MEMORANDUM

TO: Nell Donaldson, Planner
FROM: David Senus, P.E. & Ashley Auger, E.I.T.
DATE: September 20, 2012
RE: Pomeroy Street Construction, Level II Site Plan Application

Woodard & Curran has reviewed the Response to Comments on the Level II Final Site Plan Application for the Pomeroy Street extension located off of Bancroft Street in Portland, Maine. The parcel was previously approved for a Site Plan and Conditional Use Permit in August of 2005 by the City for a single family residence with attached synagogue; however, these permits have since expired. The current amended project consists of developing a single family home (Level I), an outsale lot to be sold to Square One Construction Inc. for possible development, and construction of approximately 200 linear feet of Pomeroy Street (Level II).

MINOR STREET CONSTRUCTION
POMEROY STREET
 PORTLAND, MAINE

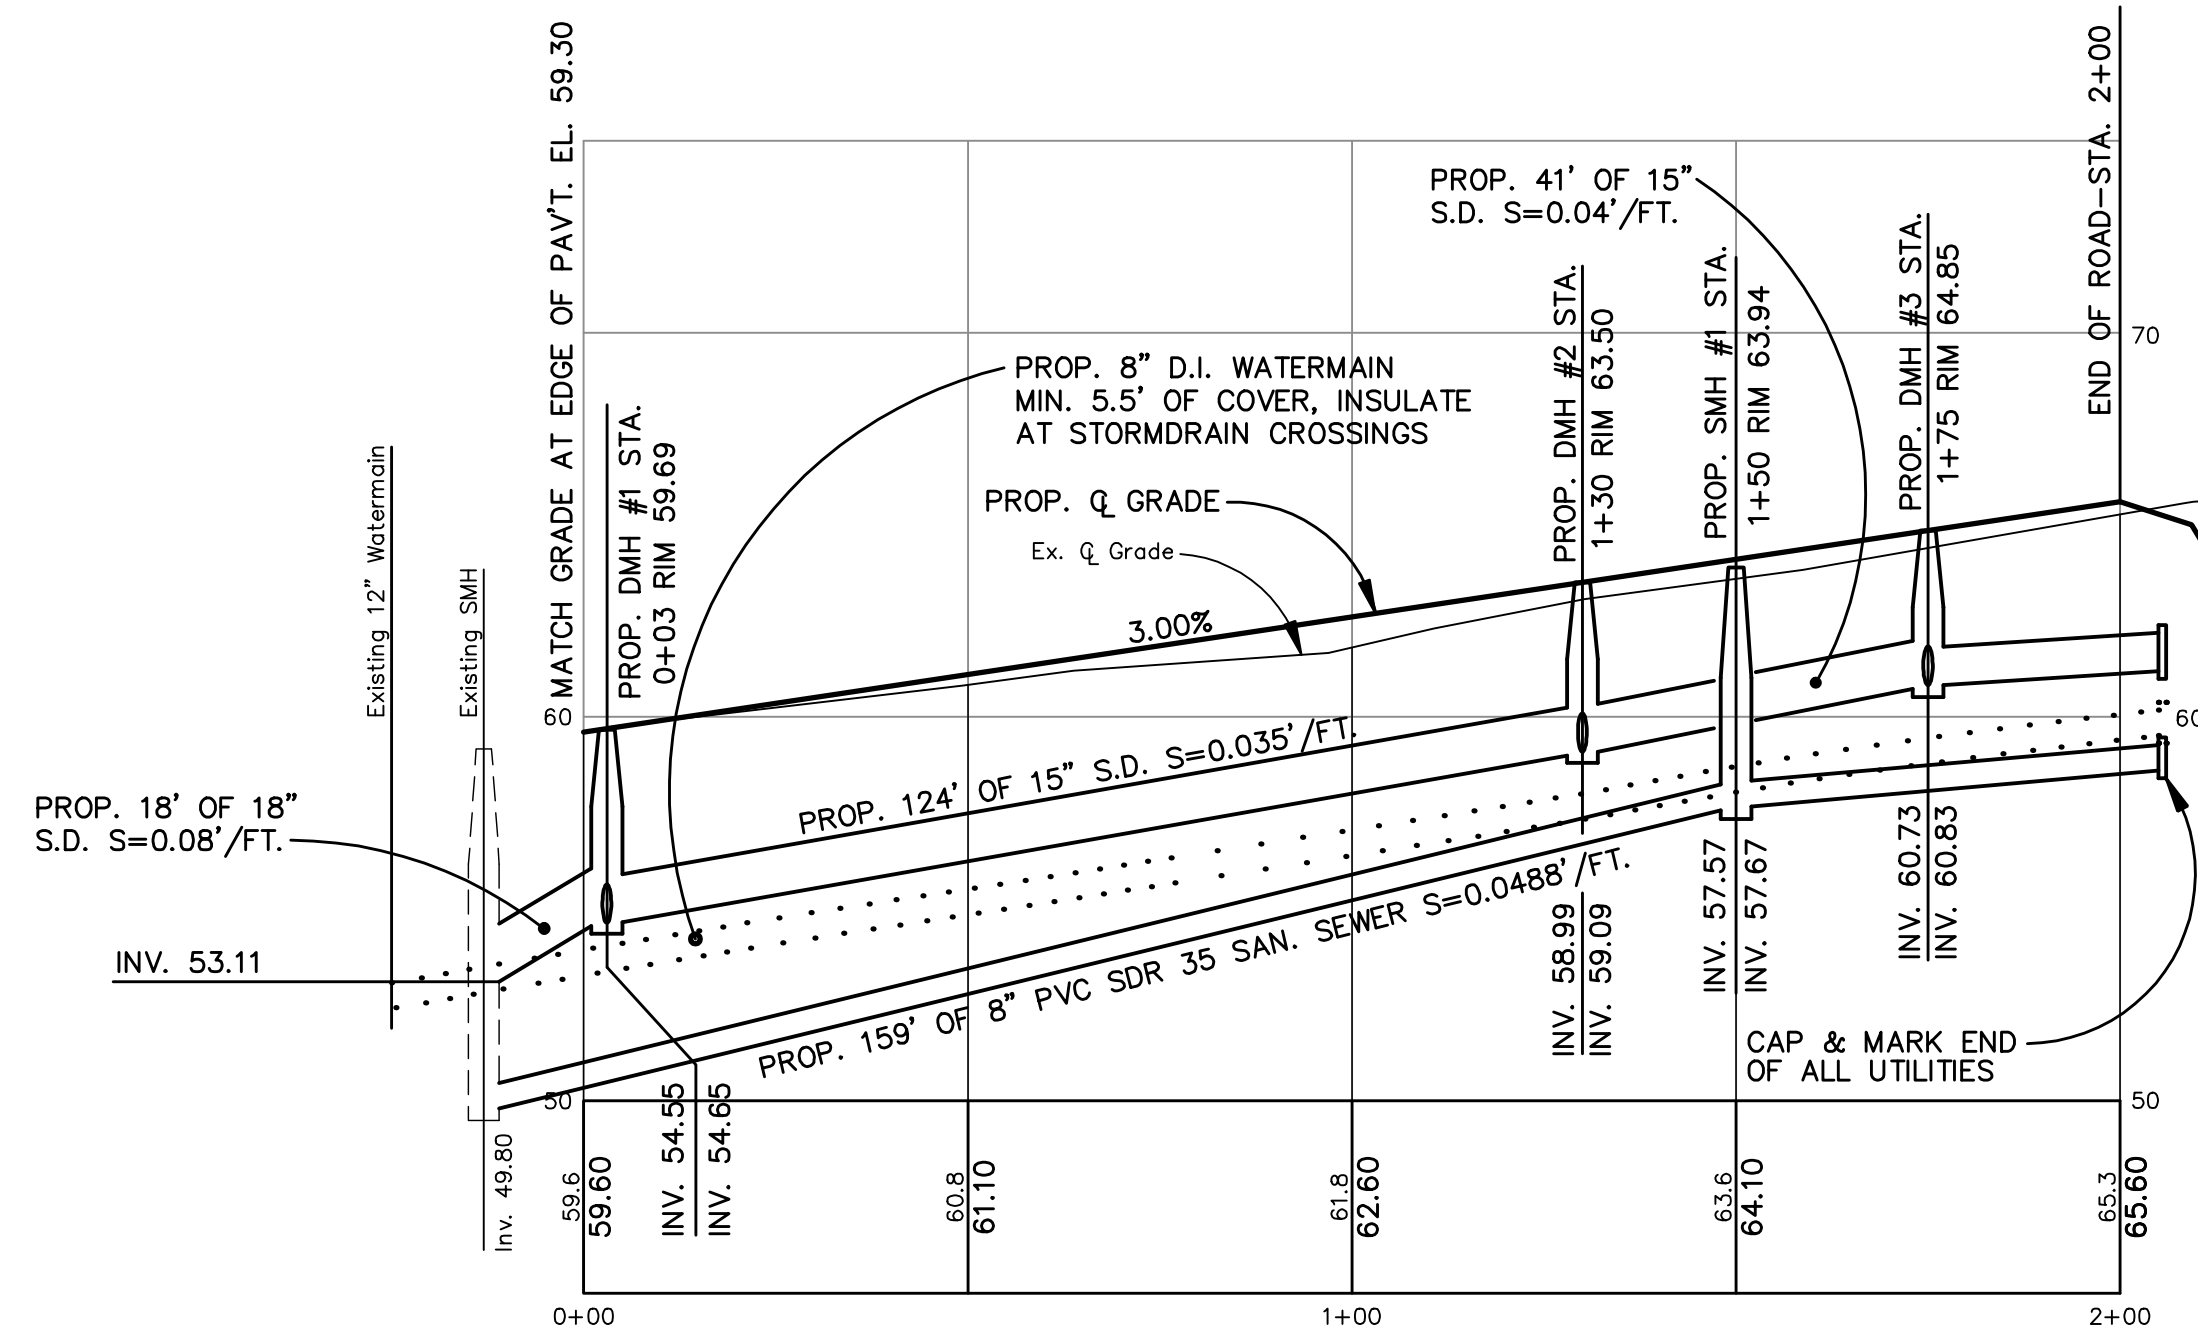
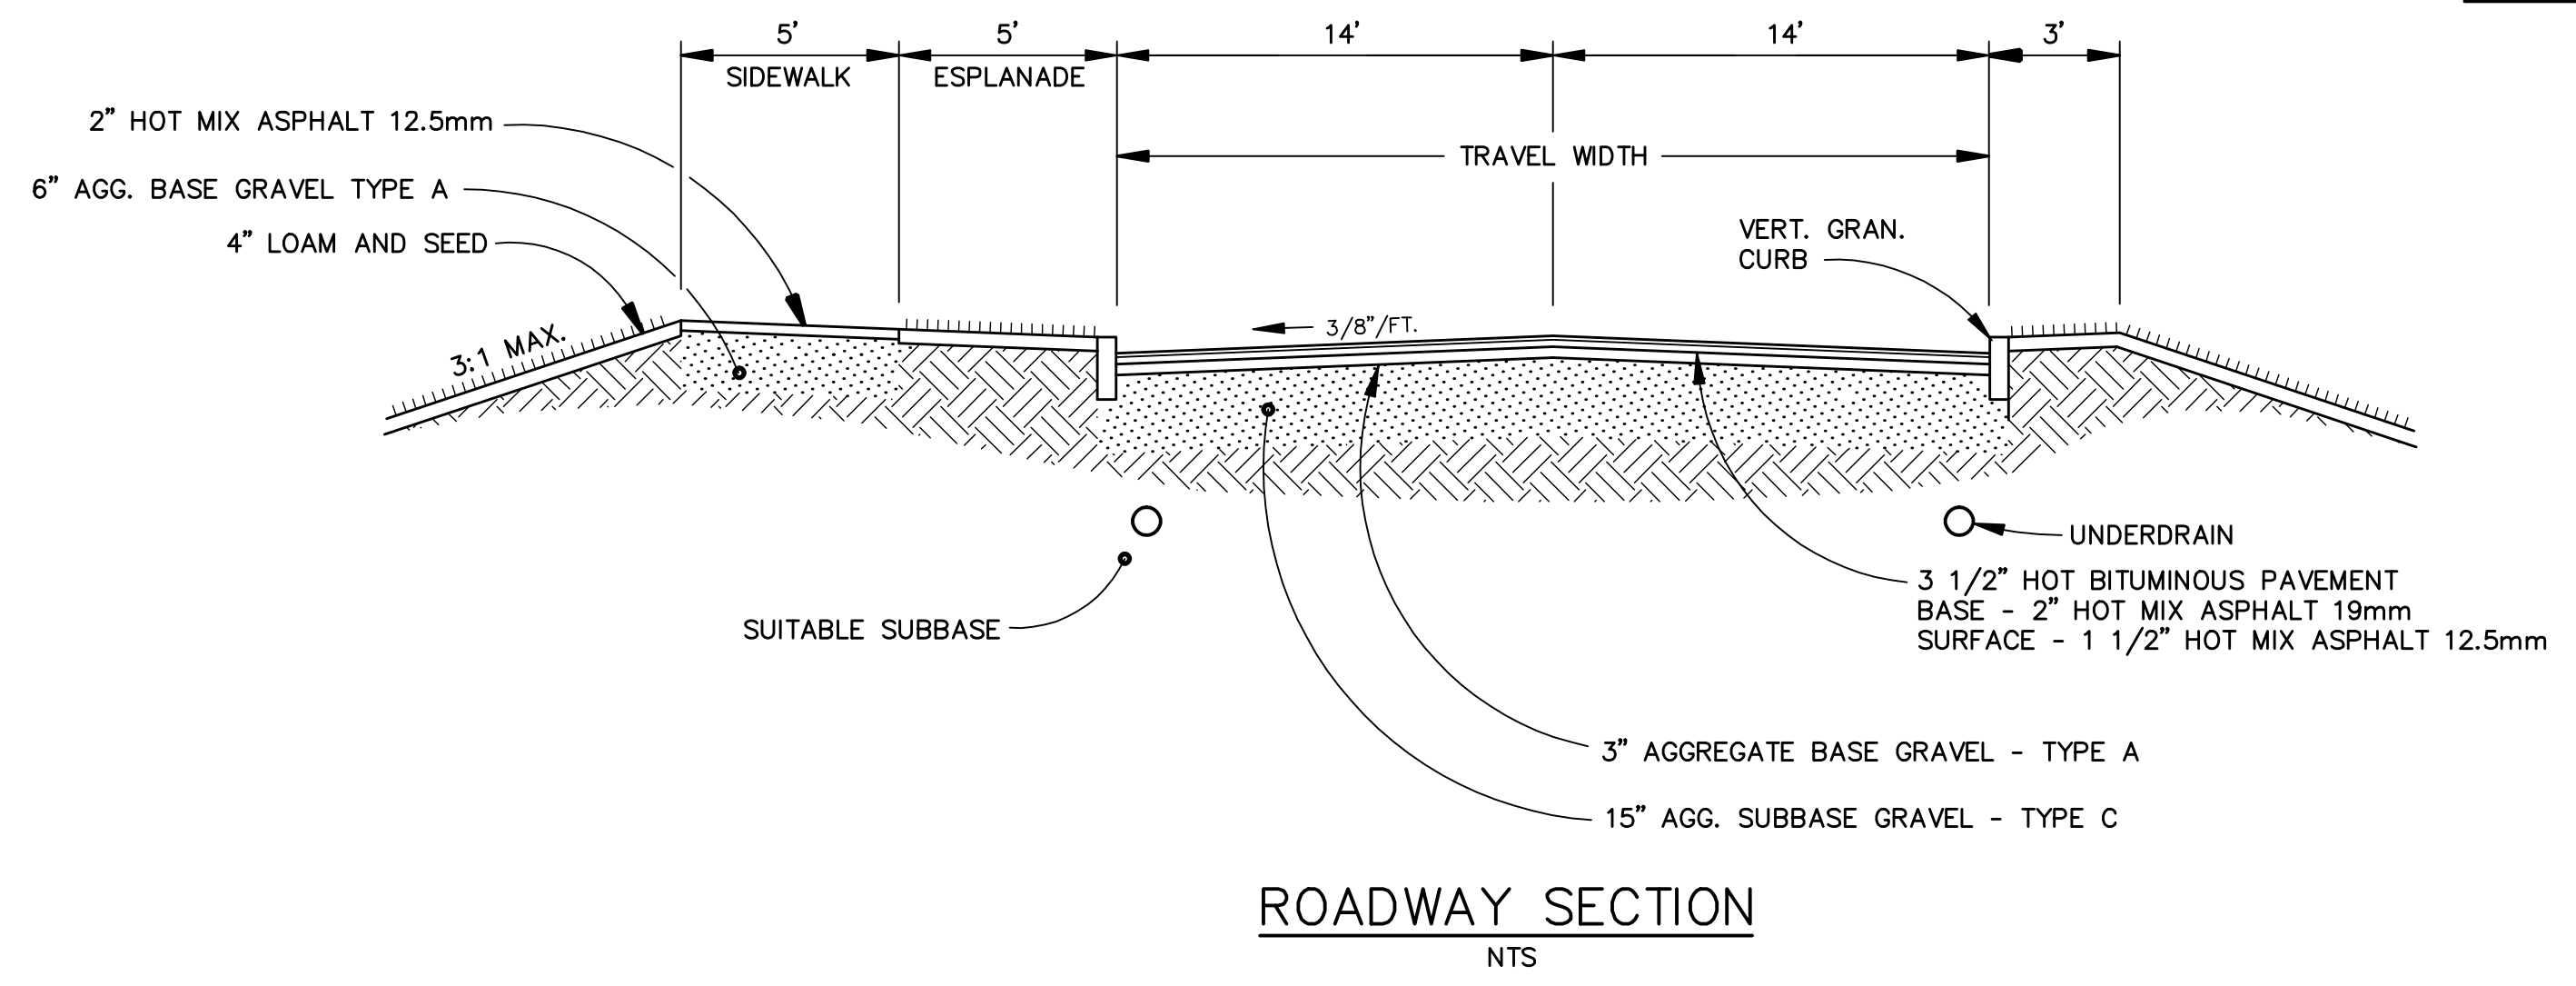
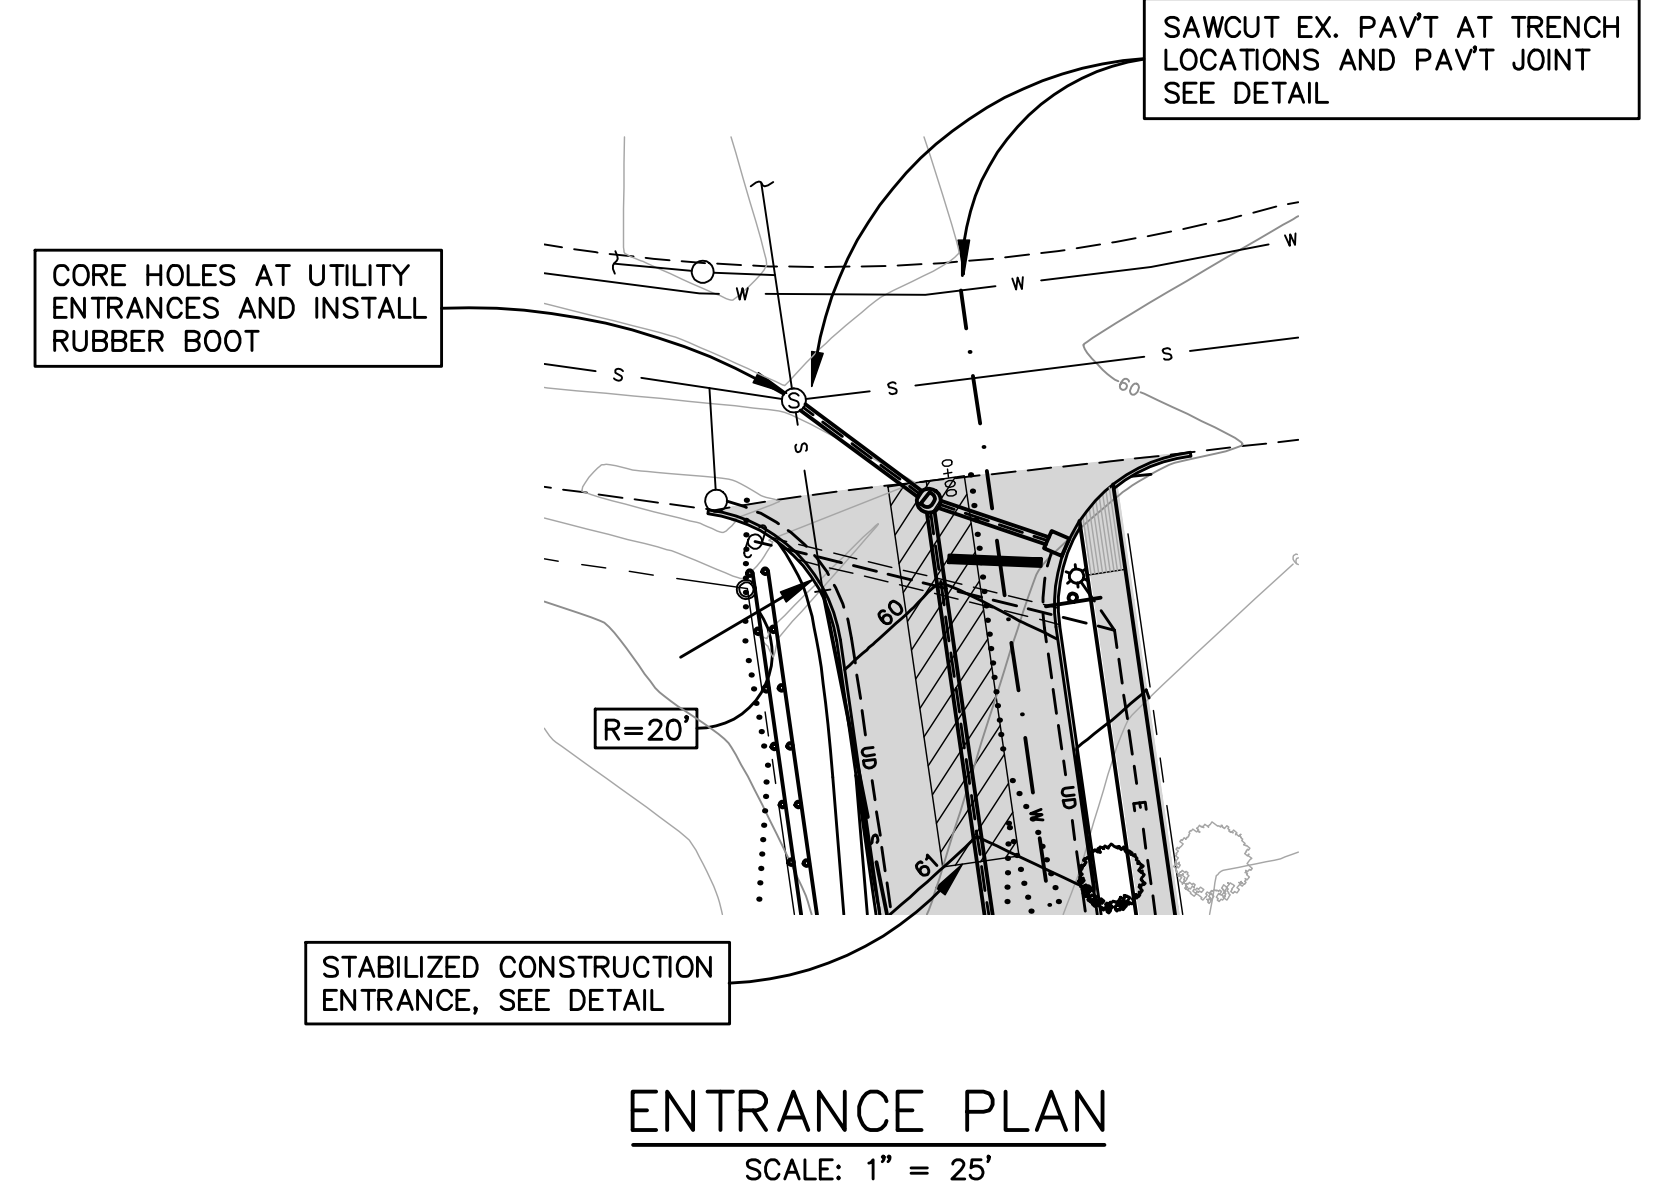
- 4) In accordance with Section 1 of the City of Portland Technical Manual:
 - a) The aggregate base course for a bituminous sidewalk should be 10" of Type B gravel per Figure I-12. **Comment has been adequately addressed.**

- b) Vertical Granite Curbing and Terminal Curb details should be per Figure I-16. **Comment has been adequately addressed.**
